Recommendation Report for Planning Permission for Works or Extension to a Dwelling

REF NO: AW/161/18/HH

LOCATION: 31 Queens Fields West
Aldwick
PO21 5SG

PROPOSAL: Single storey extension as annexe for elderly relative (resubmission following AW/208/17/HH).

Proposed Ground Floor

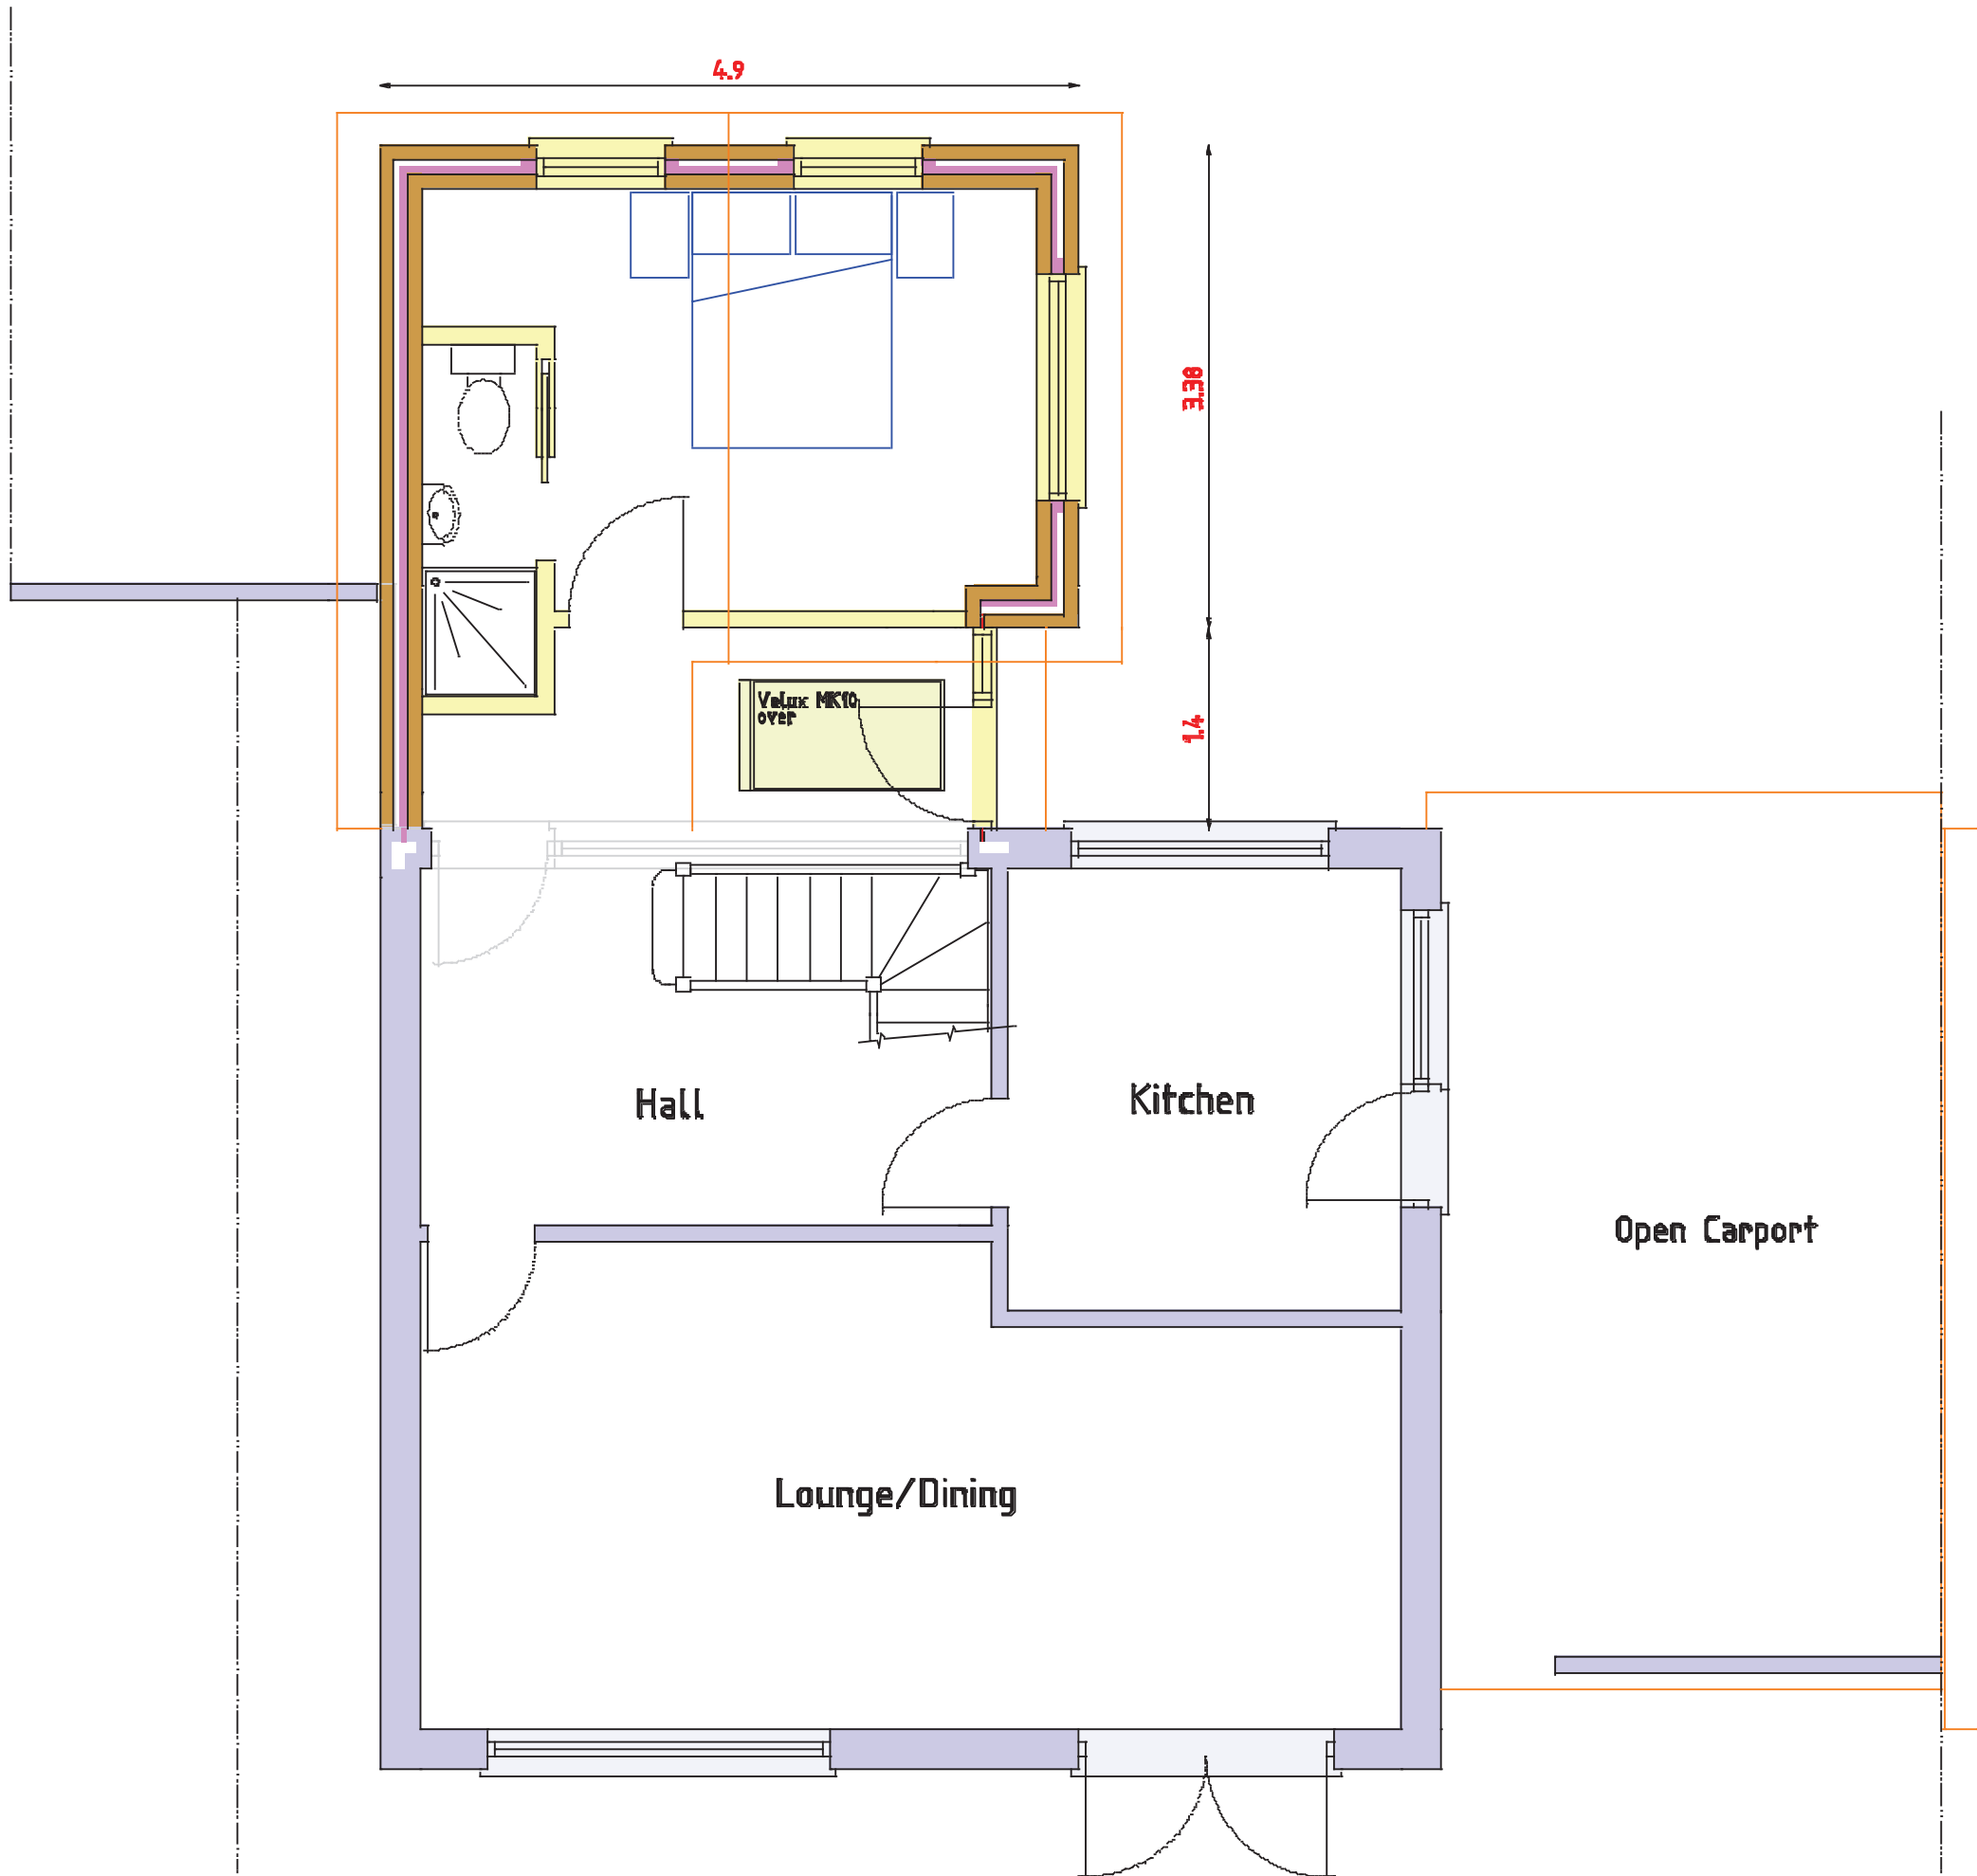
The previous planning application AW/208/17/HH was refused. This application differed from the previous application in that it is approximately 0.9m shallower, which increases the distance the proposal is from the road by 1m.

The locality has retained its open plan character, as it features no examples of large front extensions the in surrounding area. It is considered that front gardens are devoid of any significant development. Whilst it is noted that the proposal is of a lesser scale than previously, the extension is considered to be of an unacceptable scale and massing. As a result of the proposals siting at the front of the host dwelling, it is considered that the proposal would appear as a prominent and obtrusive feature in the locality, and therefore, would have cause significant harm to the open plan nature of the area, by failing to reflect or improve its character.

Therefore, the proposed development is considered to be in conflict with D DM1(1), D DM1(2), D DM4(a) and D DM4(b) of the Arun District Council Local Plan (2011-2031). This is due to its siting, scale and massing, and the resultant detrimental impact on the established character of the area and pattern of development. Additionally, the proposal conflicts with the criteria set out in 'Area 15' of the Aldwick Parish Design Statement.

- 1 The proposed extension, by virtue of its siting, scale and massing is considered to have significant harm upon the open character of the area and the character and appearance of the host dwelling. Therefore, it is in conflict with policies D DM1 and D DM4 of the Arun District Council Local Plan (2011-2031) and Area 15 of the Aldwick Parish Design Statement.
